**Thorpe Cottage
High Street
Angmering
West Sussex.
BN16 4AE**

Re: Planning applications A/24/21/PL & A/25/21A

Project
**Land at Water Lane,
Angmering, West Sussex.**
Drawing Title
Sales Area Layout

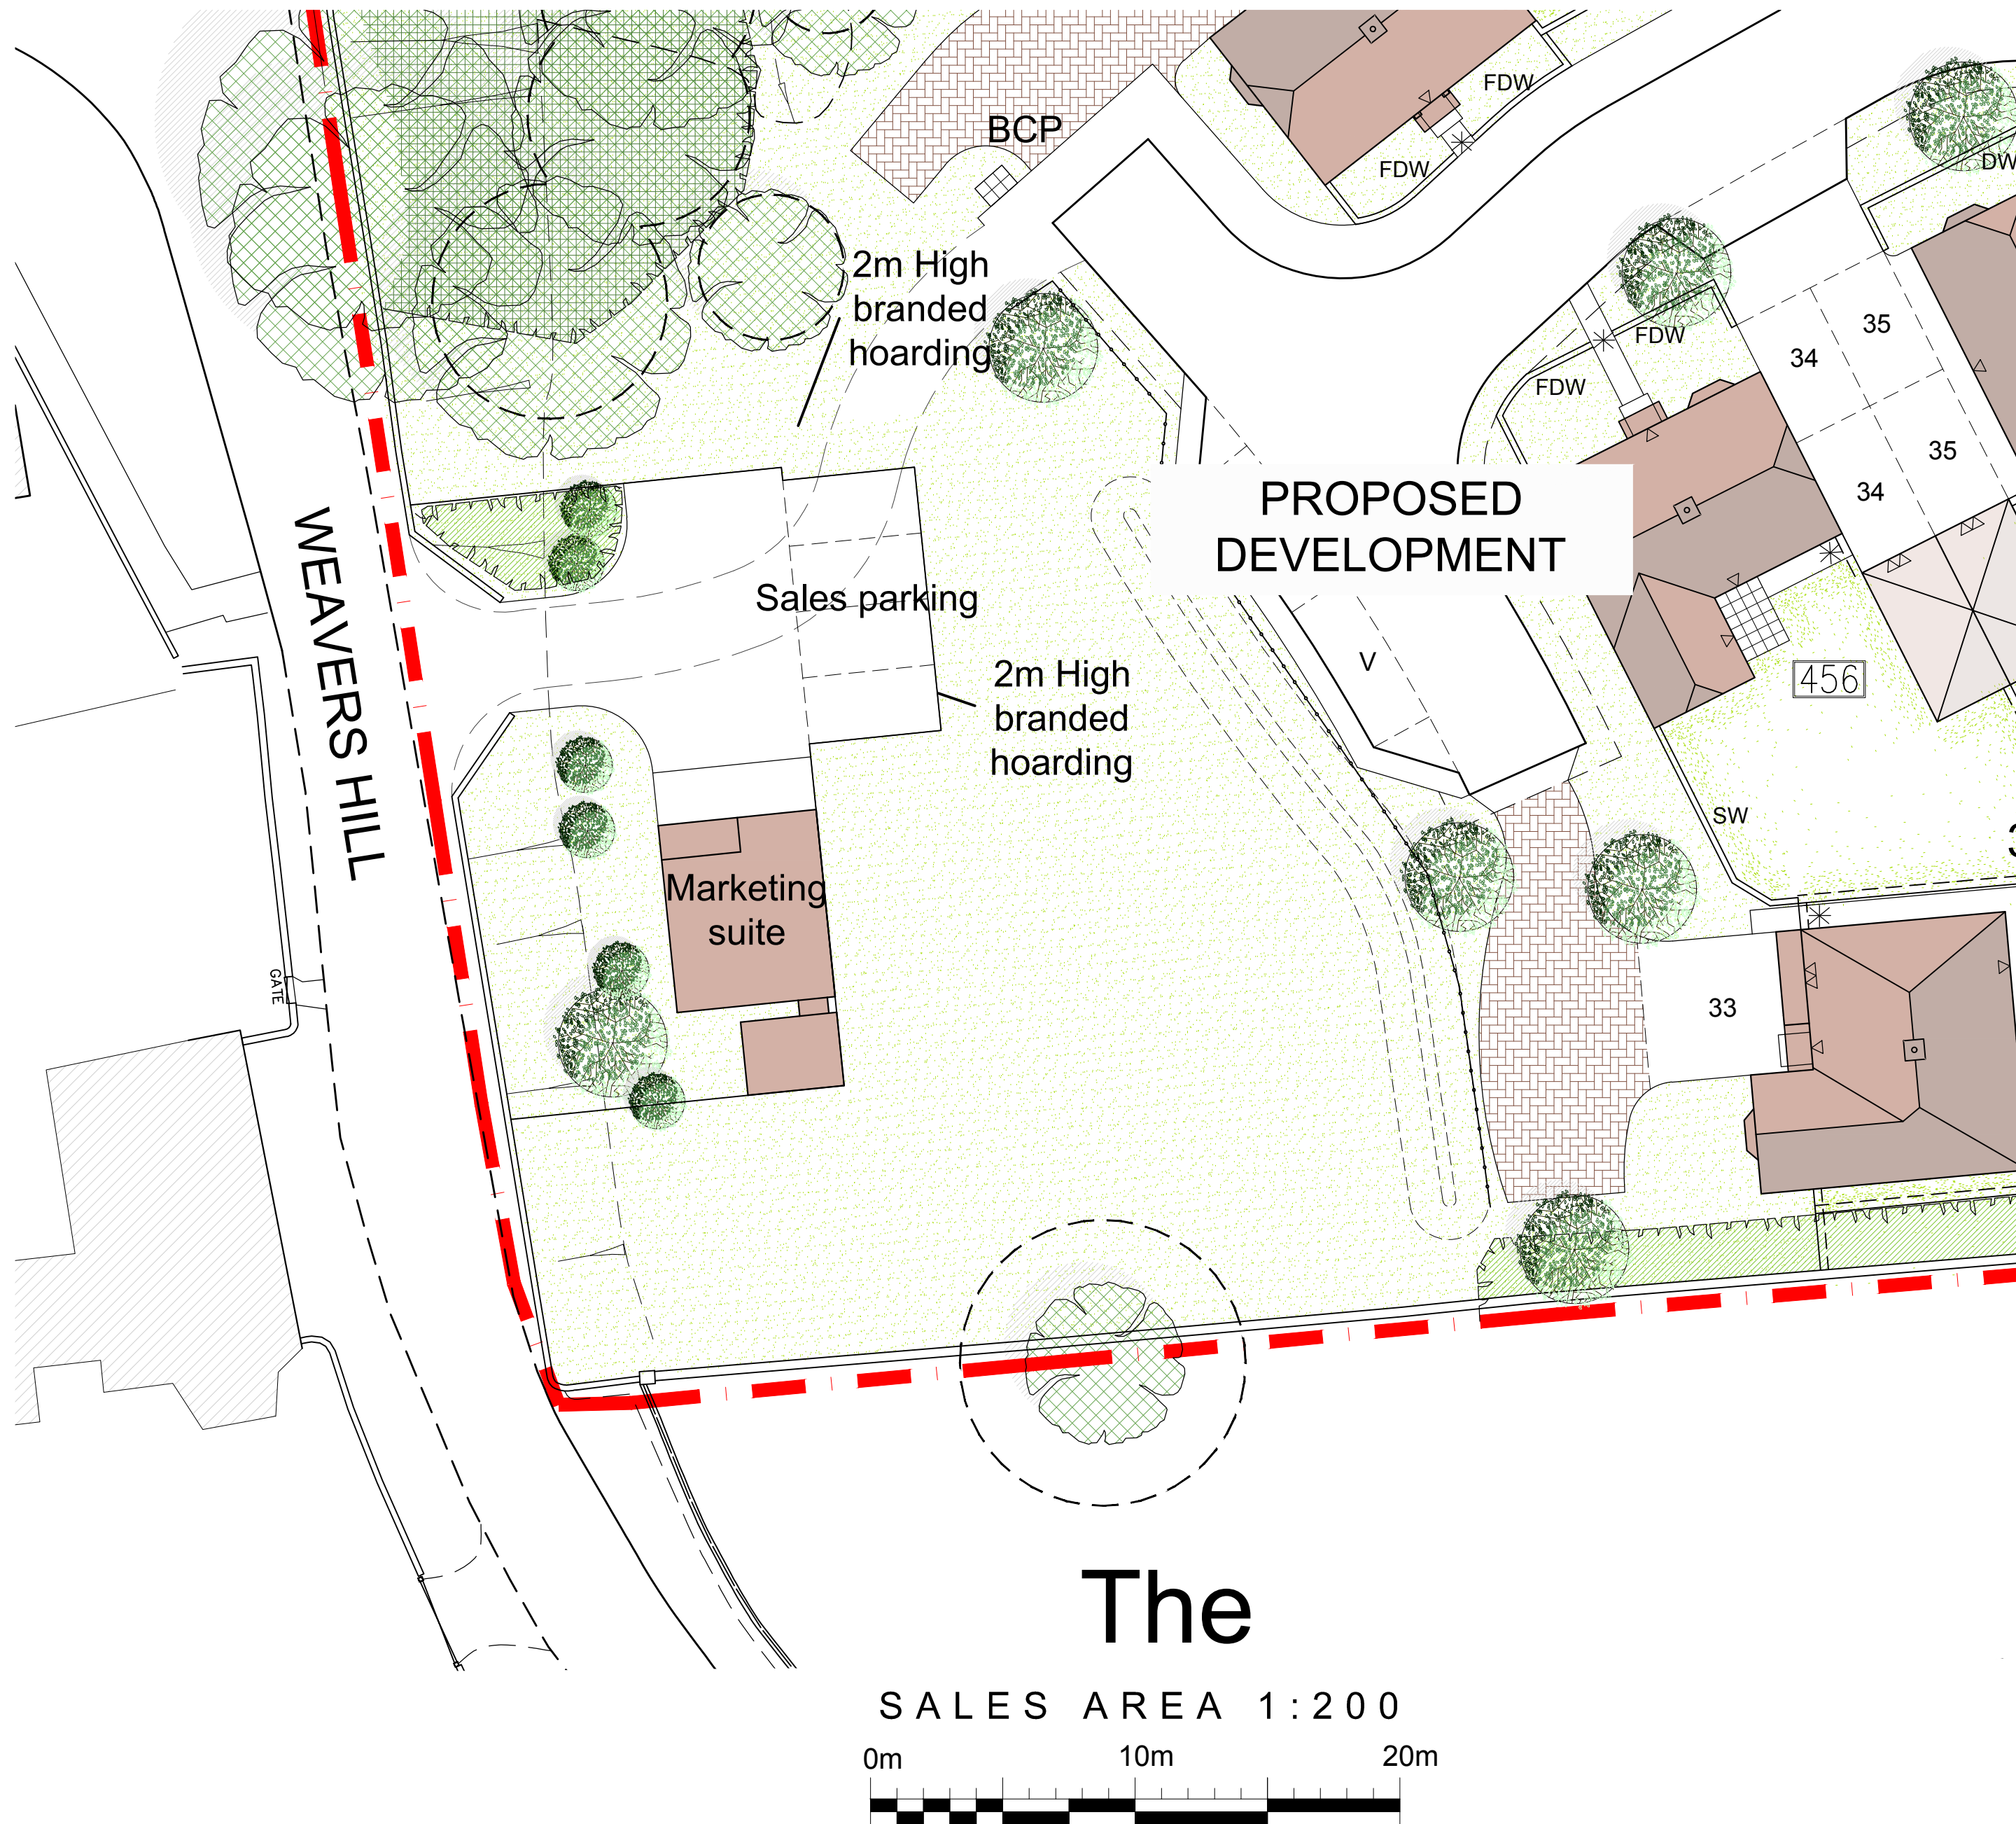
I see that the developers wish to knock down a section of the lovely old flint wall to right next to a blind bend to form an access to a sales office with flag poles together with a large hoarding for advertising purposes. There is already a gate a little further down with a lovely curved entrance within the said flint wall directly opposite Cumberland Road, this would be a far safer & more central entrance if indeed one is at all necessary. I would suggest that the infrastructure should be put in place first which is the Water Lane access & a sales office or show home be at that point along the main Water Lane road into the village.

This proposal I feel would be dangerous & a complete travesty to what is clearly a beautiful old part of the village.
